ALDWICK PARISH COUNCIL

Town & Country Planning (Control of Advertisement) (England) Regulations 2007 (as amended)

Application No: AW/120/20/A
Site Address: One Stop Convenience Store Aldwick Street Aldwick PO21 3AP
Description of works: Changes to approved window graphics.

PROPOSED SITE SIGNAGE

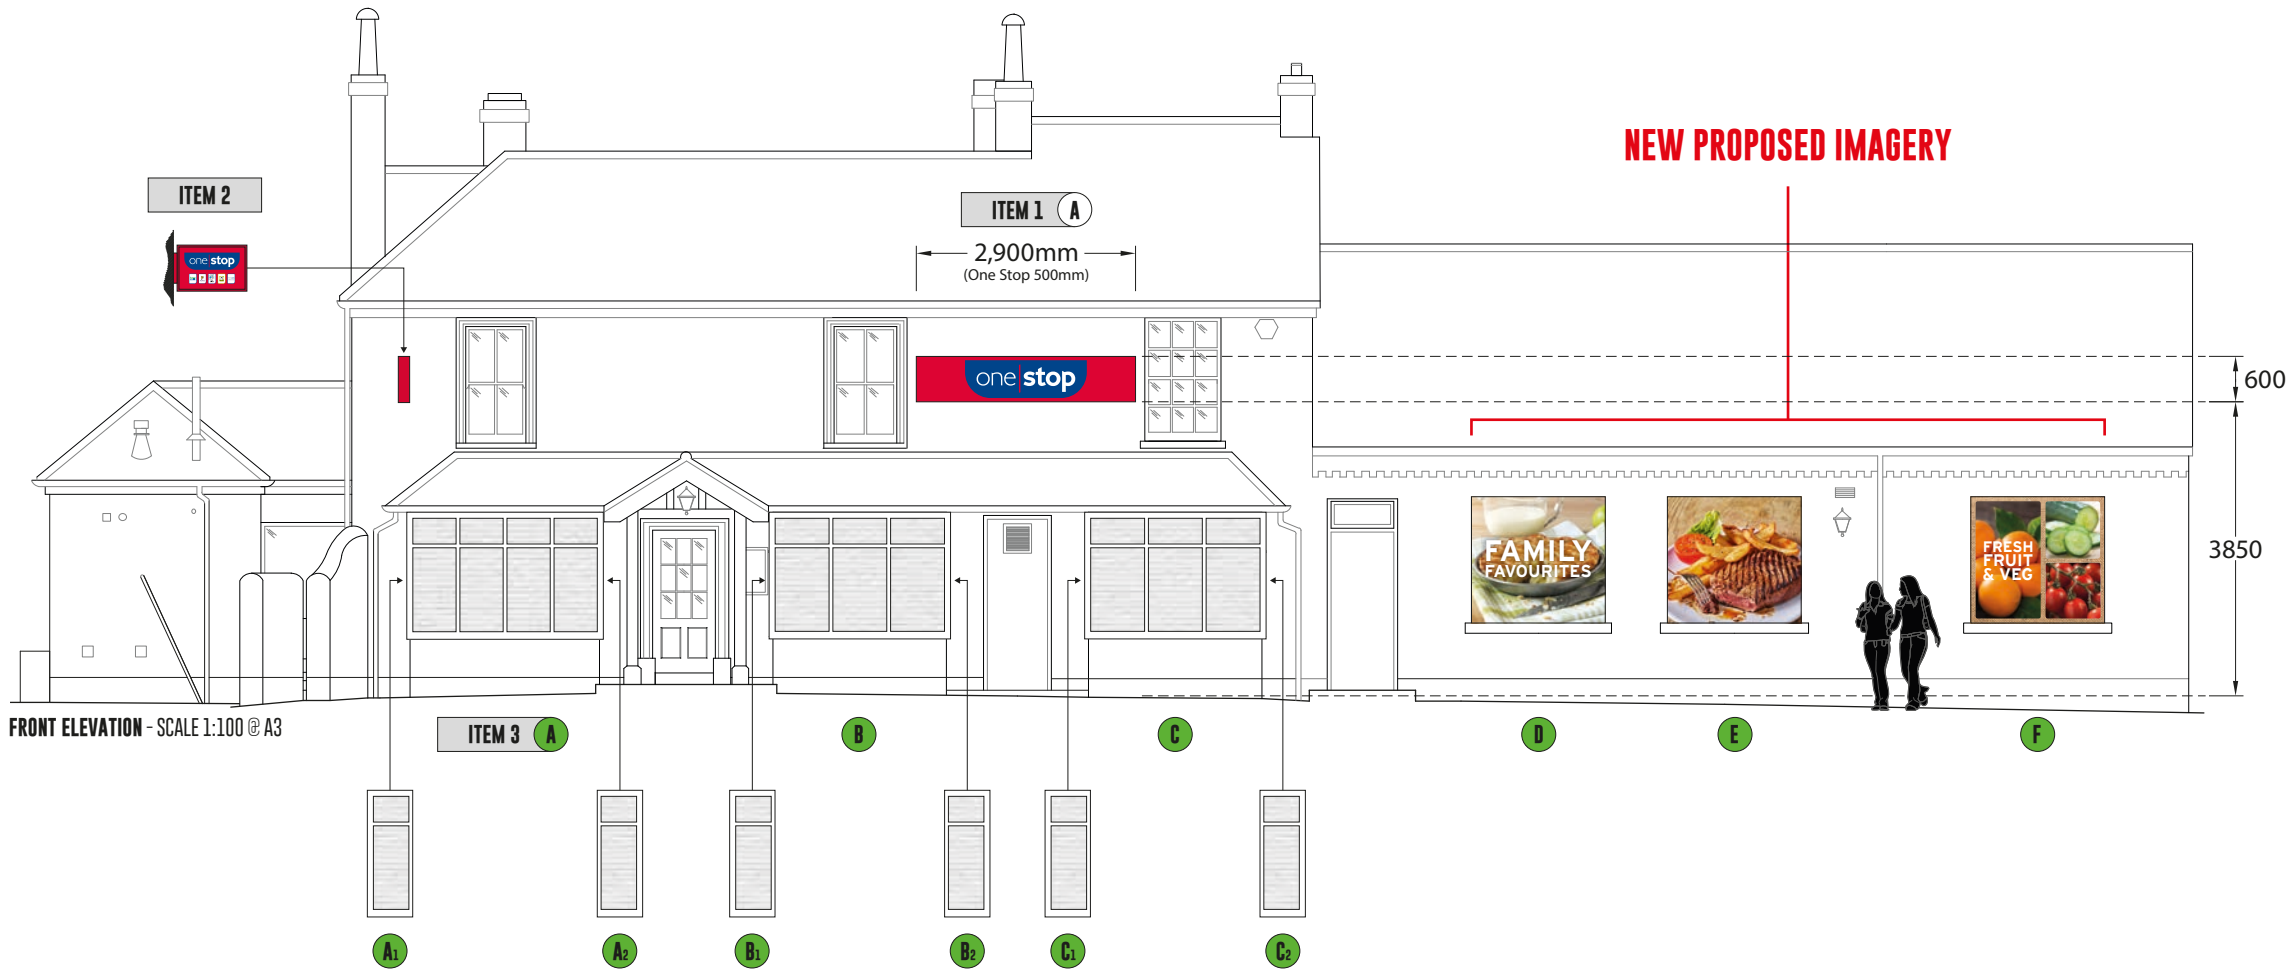
Members noted that there was no reference to text and therefore
presumption of the illustrations to be shown as: steak and chips (Illustration E); apple pie and cream (illustration D) and, finally, oranges, cucumber and cherry tomatoes (illustration F).

The planning committee acknowledge that planning permission has already been given for similar signs but would wish to reiterate that these similar signs are completely out of keeping with the village setting of this proposed re-development and, should permission be granted, further thought should be given to the nature and type of graphics - for instance street views of "old" Aldwick Street
Furthermore, the signage still does not ensure that the frontage is in keeping with its context including the surrounding street scene and the existing features, scale and proportion of the building. And that it still does not provide an appropriate balance between the need to advertise, and respect for the existing character of the street scene. (ADC Supplementary Design Guidance 2003 and draft Supplementary Design Guidance 2020 yet to be adopted).
